APPLICATION NO. <input type="checkbox"/> 03 DRB - 00046	PROJECT NO. <input type="checkbox"/> 1002023
PROJECT NAME INDIAN FARMS	
EPC APPLICATION NO.	
APPLICANT / AGENT WAYDAN / PETE	PHONE NO. 255-2052
ZONE ATLAS PAGE G-13	
ONE STOP COMMENT FORM LOG

D.R.B. CASE NO.: 1002023 DATE: 6/26/02 ITEM NO.: 11

REQUEST FOR: Sketch Plat

**11. Project #1002023
Application # 02DRB-00923
Indian Farm Estates**

PLAT OF  
 LOTS 10-A, 10-B AND 10-C  
 INDIAN FARM ESTATES  
 ALBUQUERQUE, BERNALILLO COUNTY, NEW MEXICO

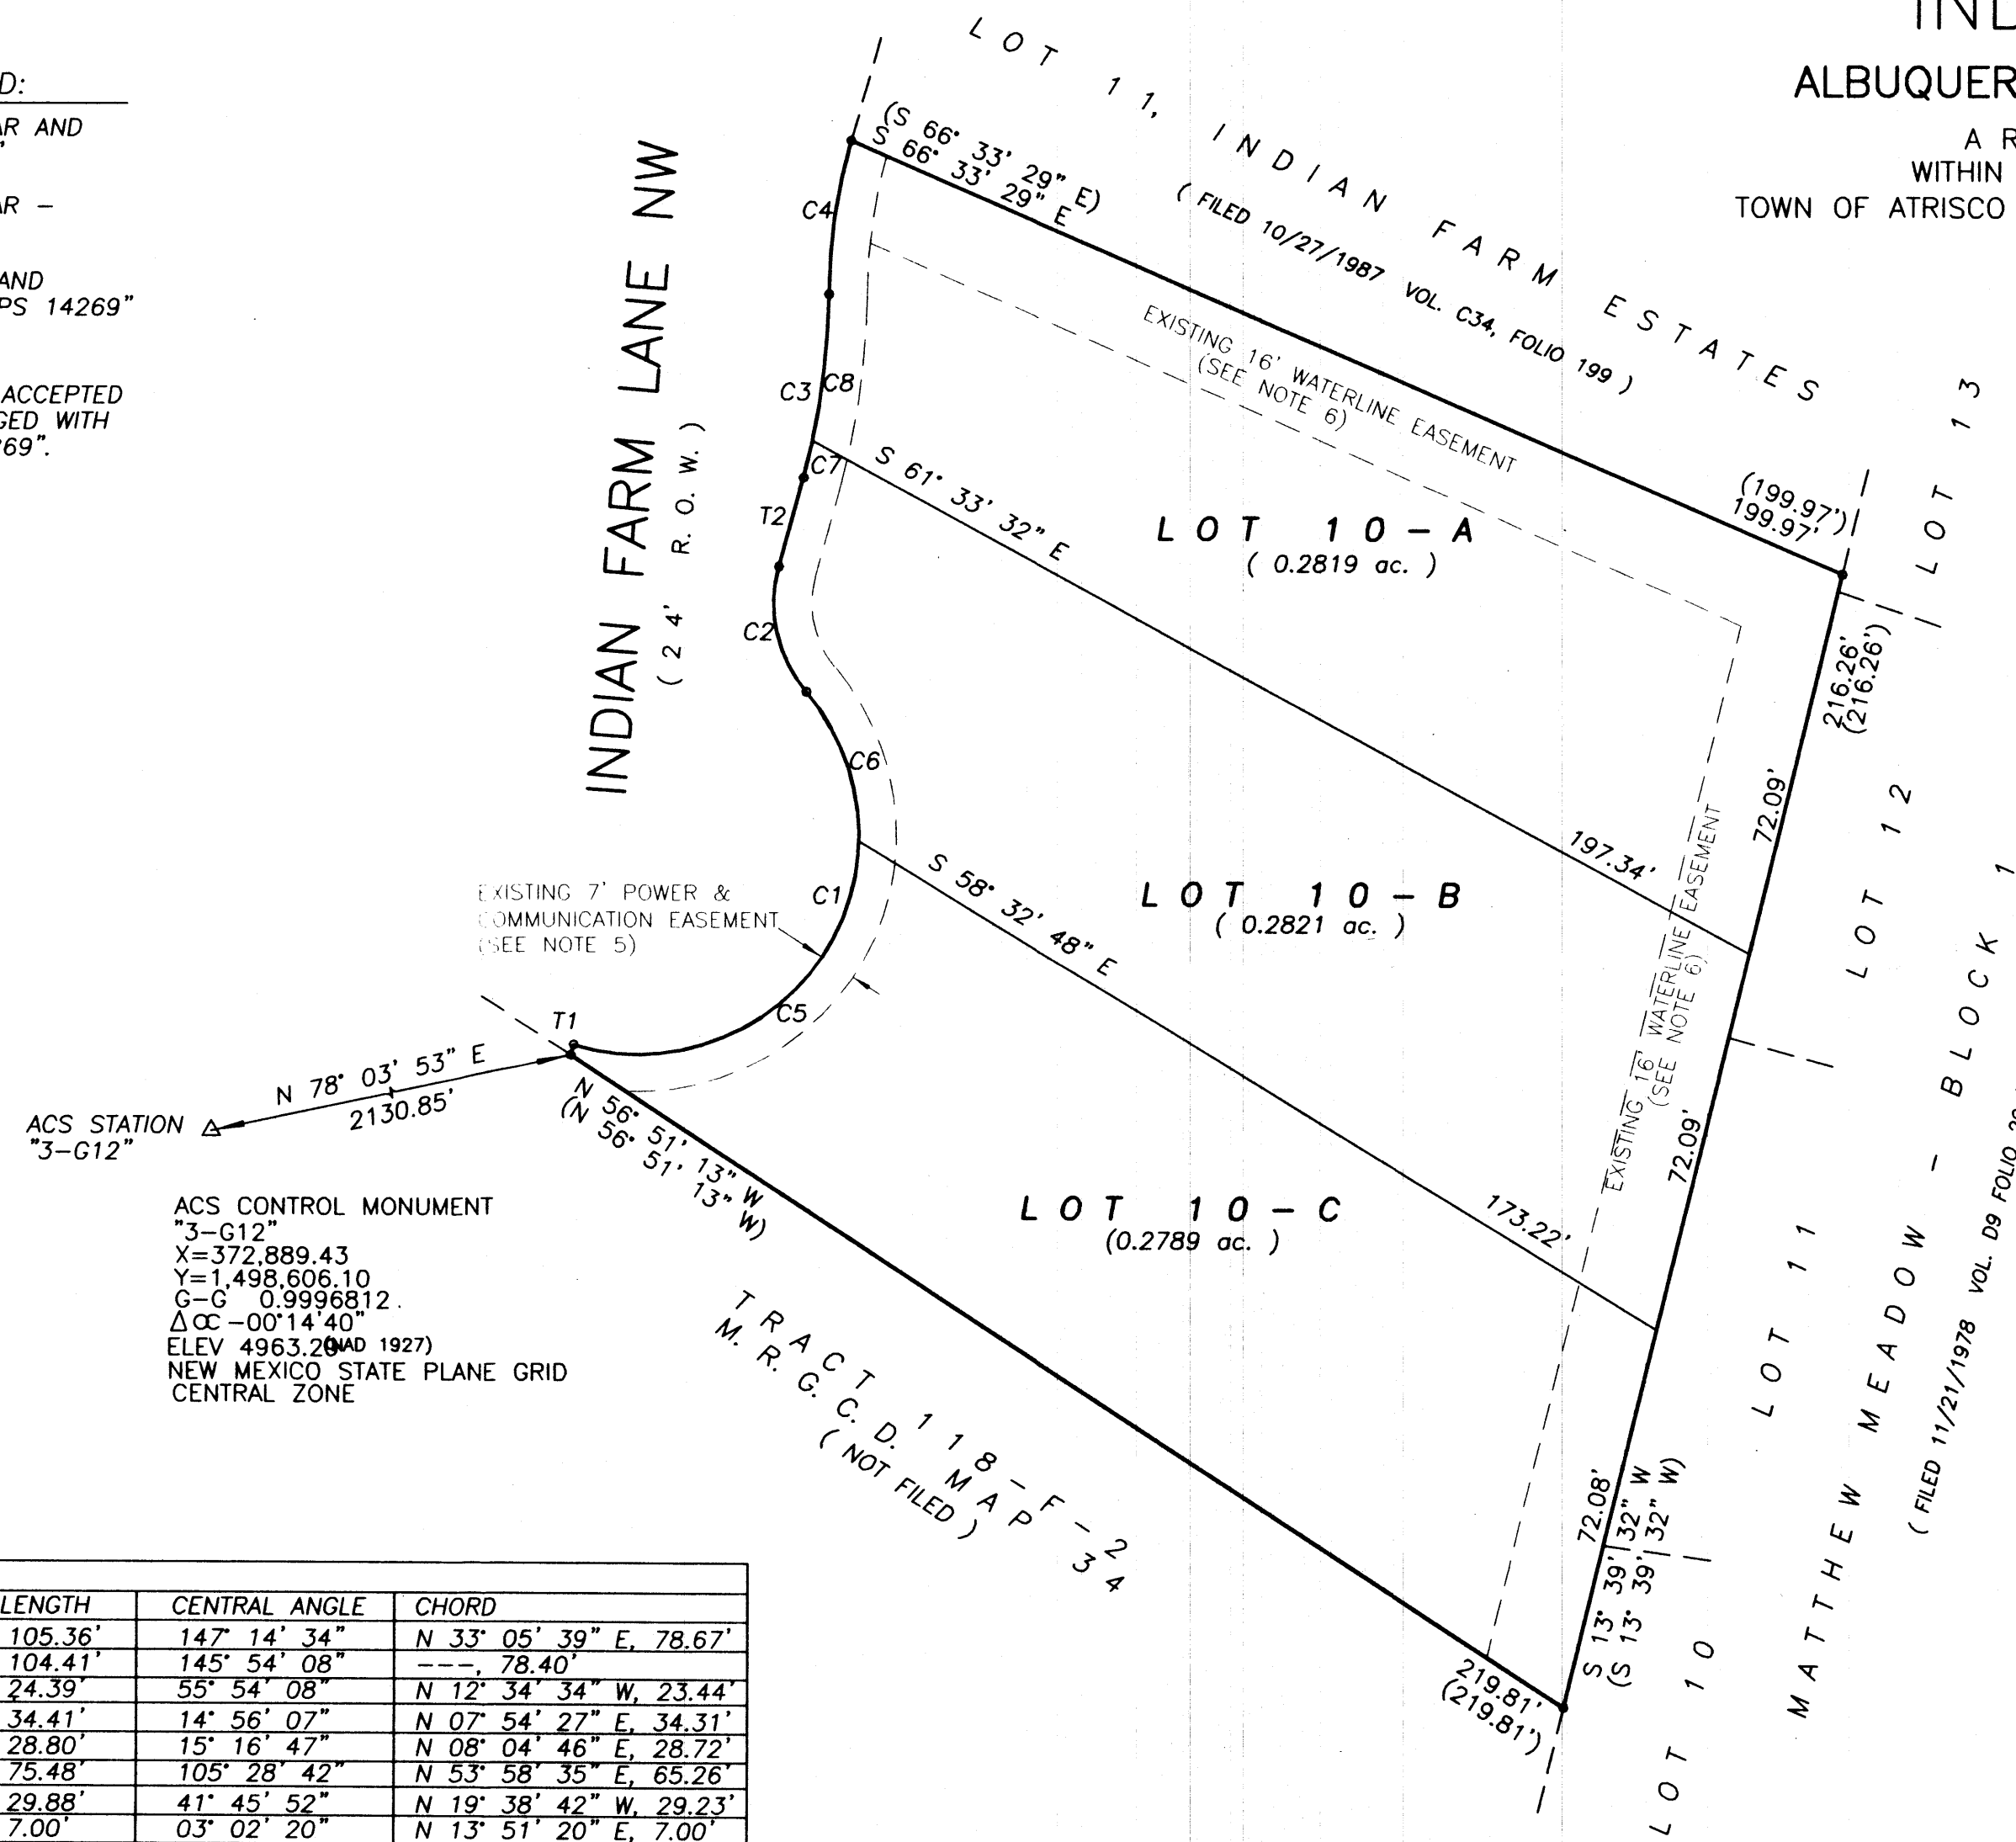
1. 6-inch public waterline is along back of lots. Meters cannot be located in backyards, must be located in public ROW (Indian Farm Lane).
2. Dedicate a wider easement for the existing 6-inch public line. Exist. easement is only 16-ft wide + this needs to be wider if it is also going to accommodate a landscape buffer.

3. Require a survey w/ prelim plat submitted.

1. According to Section 14-16-2-5 of the Zoning Code, the RA-2 classification requires a minimum lot size of 10,890 square feet and a minimum lot width of 75 feet. Contact Tom Rojas, 924-3938 for additional information about the variance process. It appears that a lot width variance will be required in order to proceed with the platting action.
